## APPENDIX 1 - CONSULTATION LOG AND ABORIGINAL PARTY COMMENTS

**RE: NUNDAH BANK THIRD TRACK CULTURAL HERITAGE  
ASSESSMENT**

Thank you for the report dated October 2010. As noted, Sarah Hall (Cultural Heritage Fieldworker) of Wanaruah LALC participated in the surveys undertaken for this project. I have reviewed the report and comment as follows. I am sure you have been made aware of the 'cultural' sensitivity of the study area and therefore the Wanaruah LALC support the recommendations put forward by the traditional stakeholders in the protection and conservation of the sites.

Figure 9a

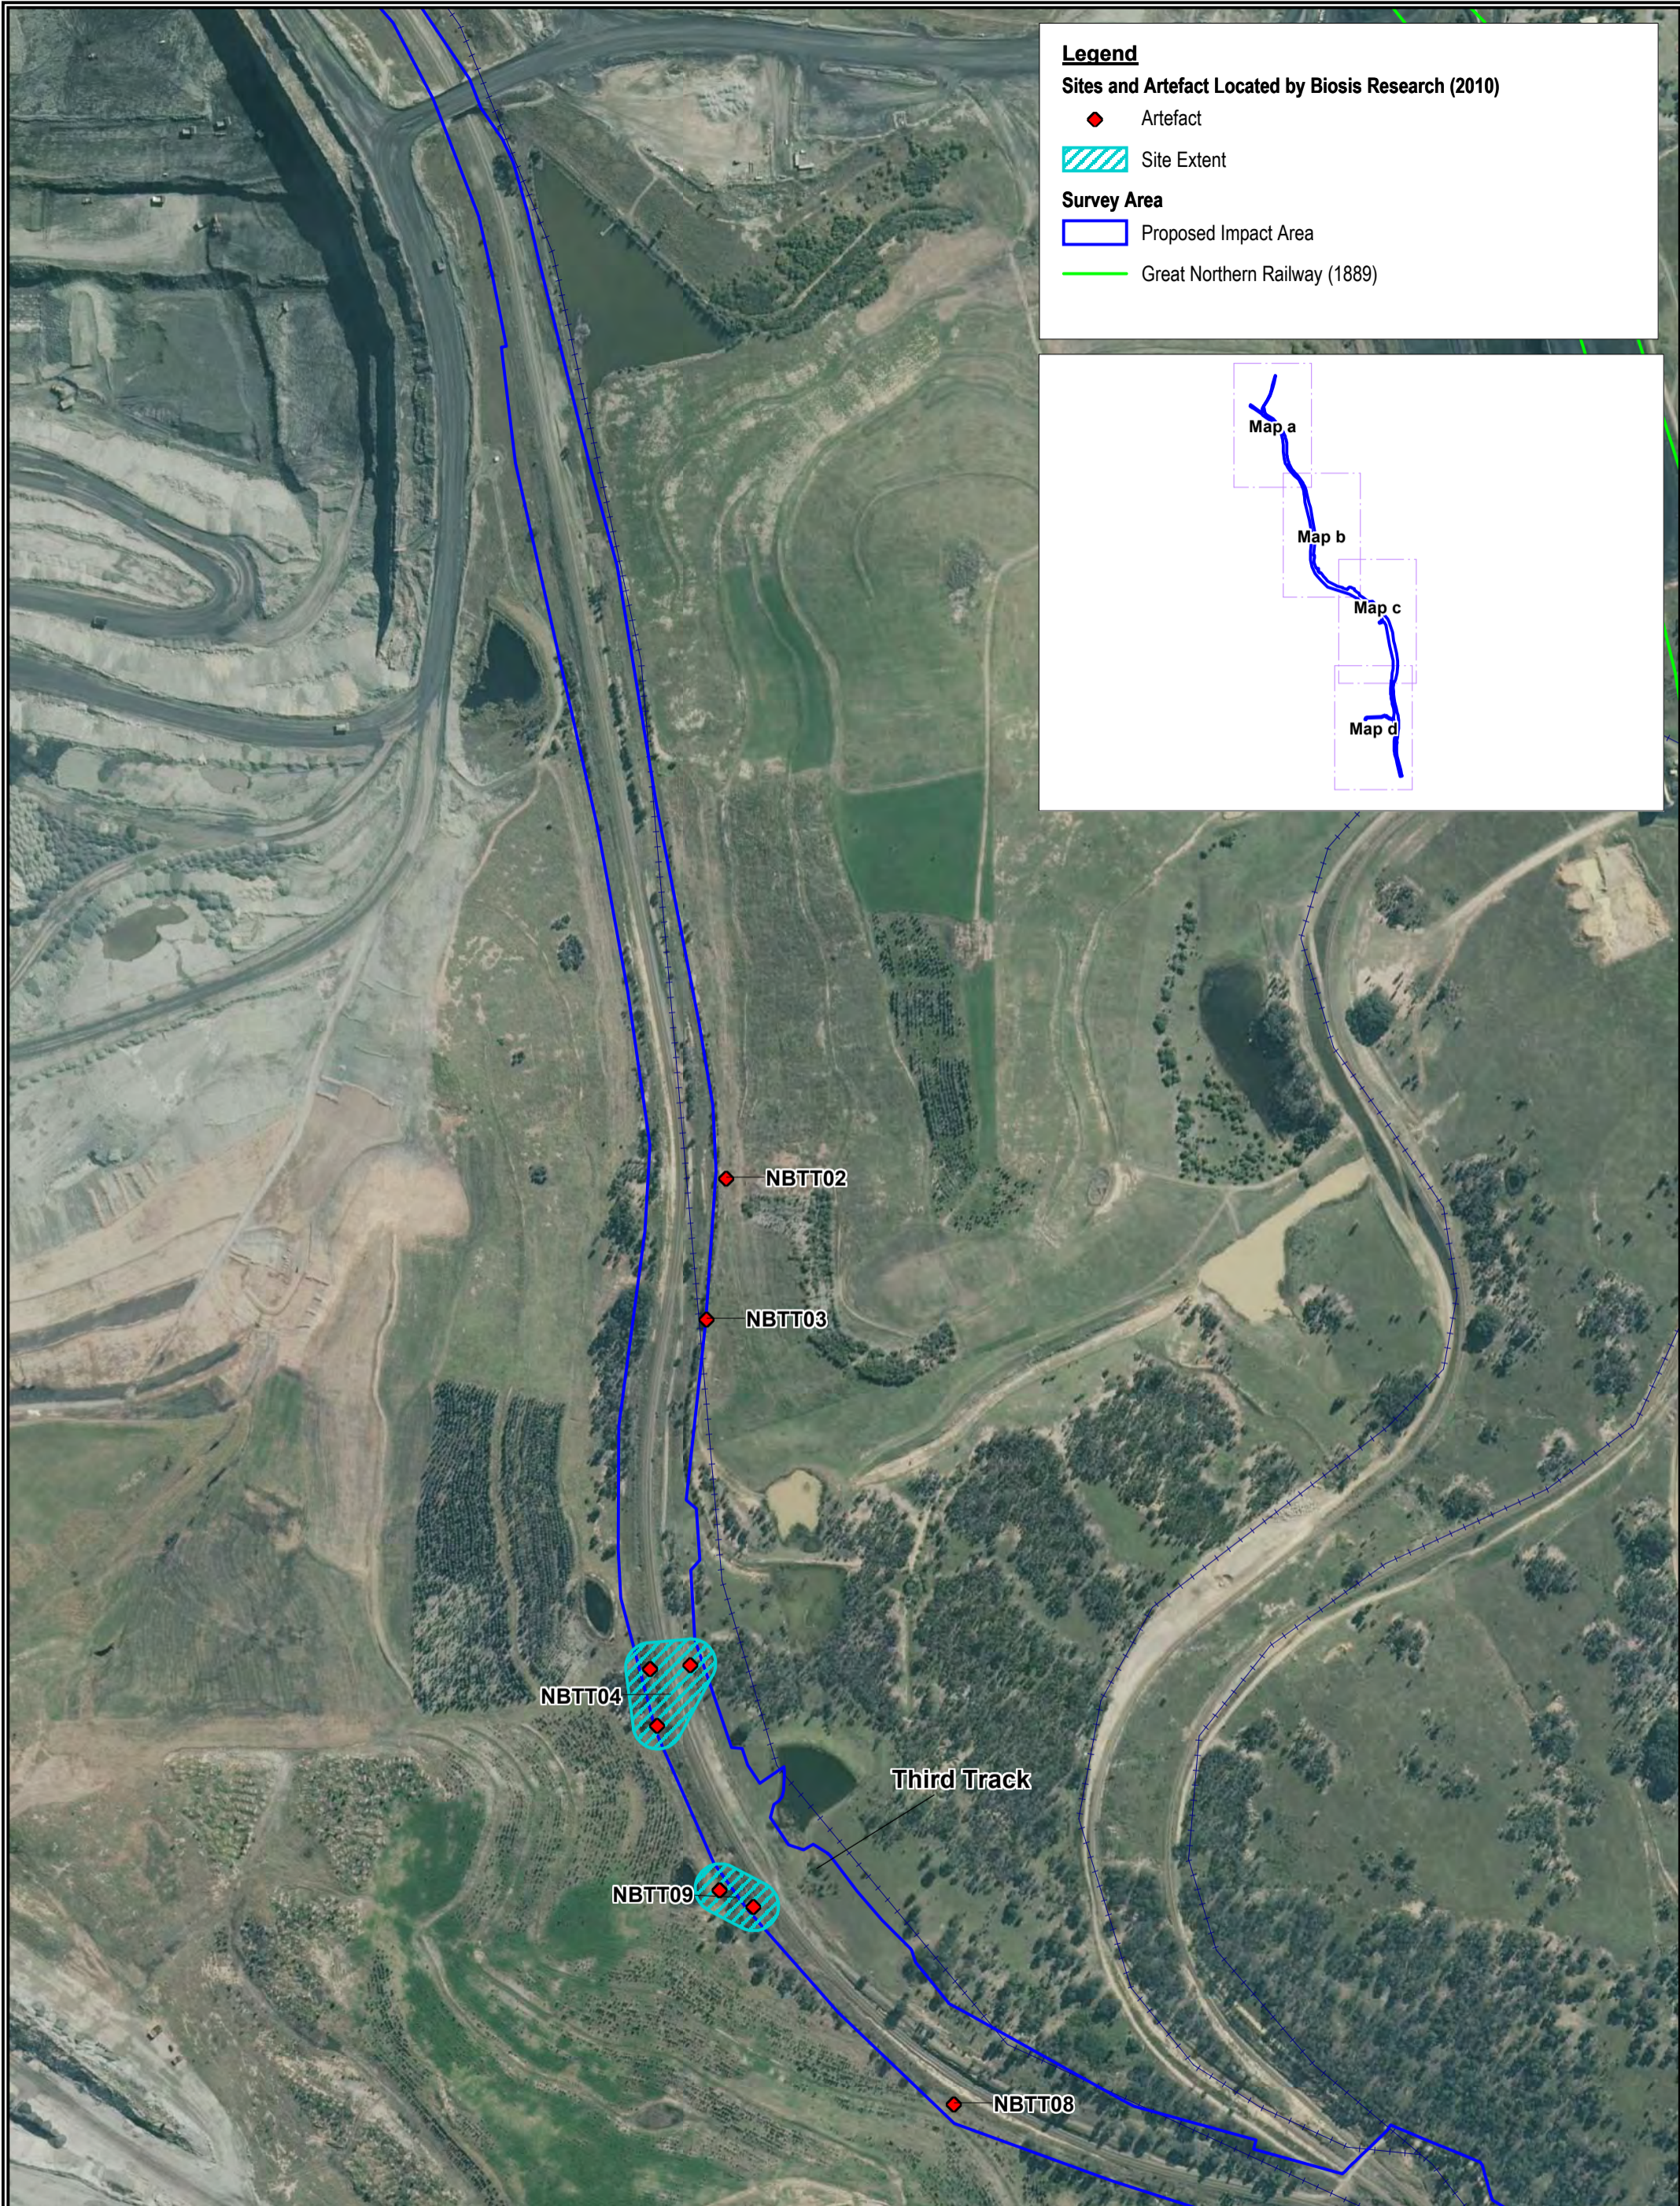
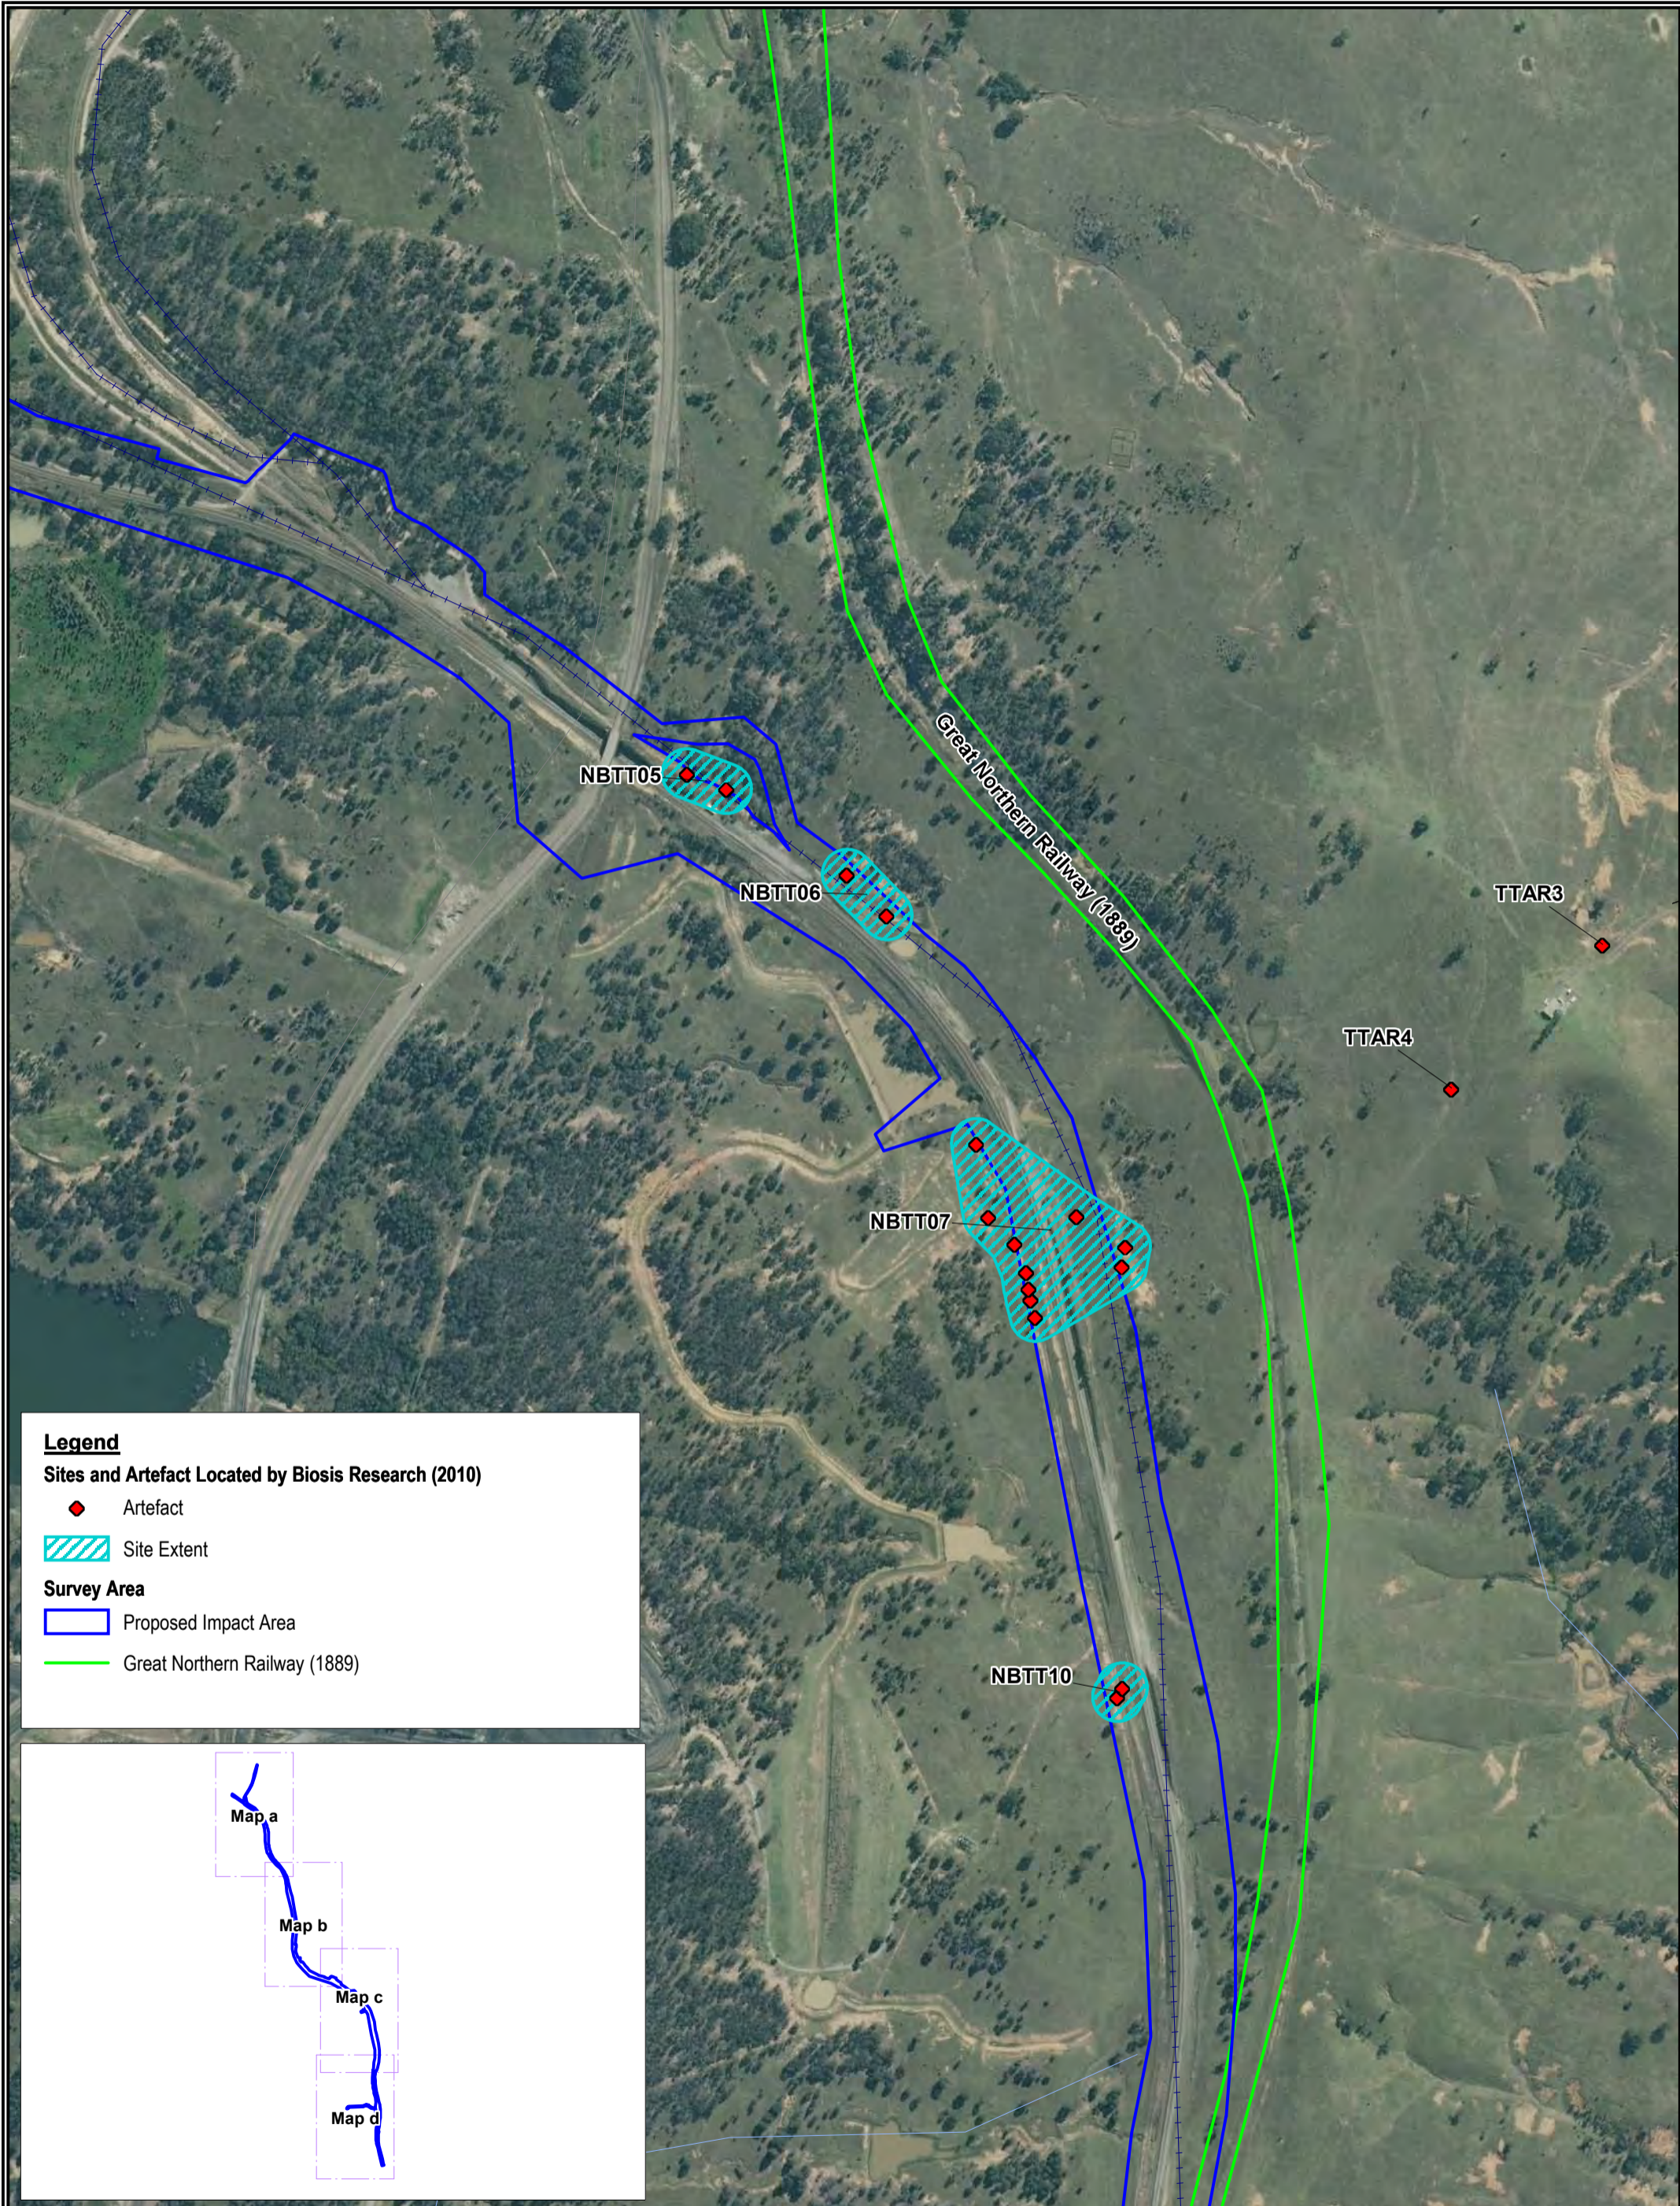
- That artefact salvage in accordance with a DECCW s90 AHIP is appropriate for all sites identified and recorded within the 'Project Area' marked on Figures 9a to 9e. This also includes those sites which are marked on the boarder of the 'Project Area' corridors. Railway construction is extremely detrimental to artefact sites and just placing fences around them will not protect the sites from heavy machinery etc.

- Those sites identified with 'Site Extent' should be further tested and salvaged in accordance with a DECCW s90 AHIP if you believe that there is subsurface material, particularly if the extent of an artefact scatter is over a wide area.

- Those sites identified and recorded outside the 'Project Area' corridors are to be temporarily fenced with relevant signage so that they will be protected during the rail line construction and truck and vehicle movements etc. nearby (eg. >5m outside and beyond the corridor edge).
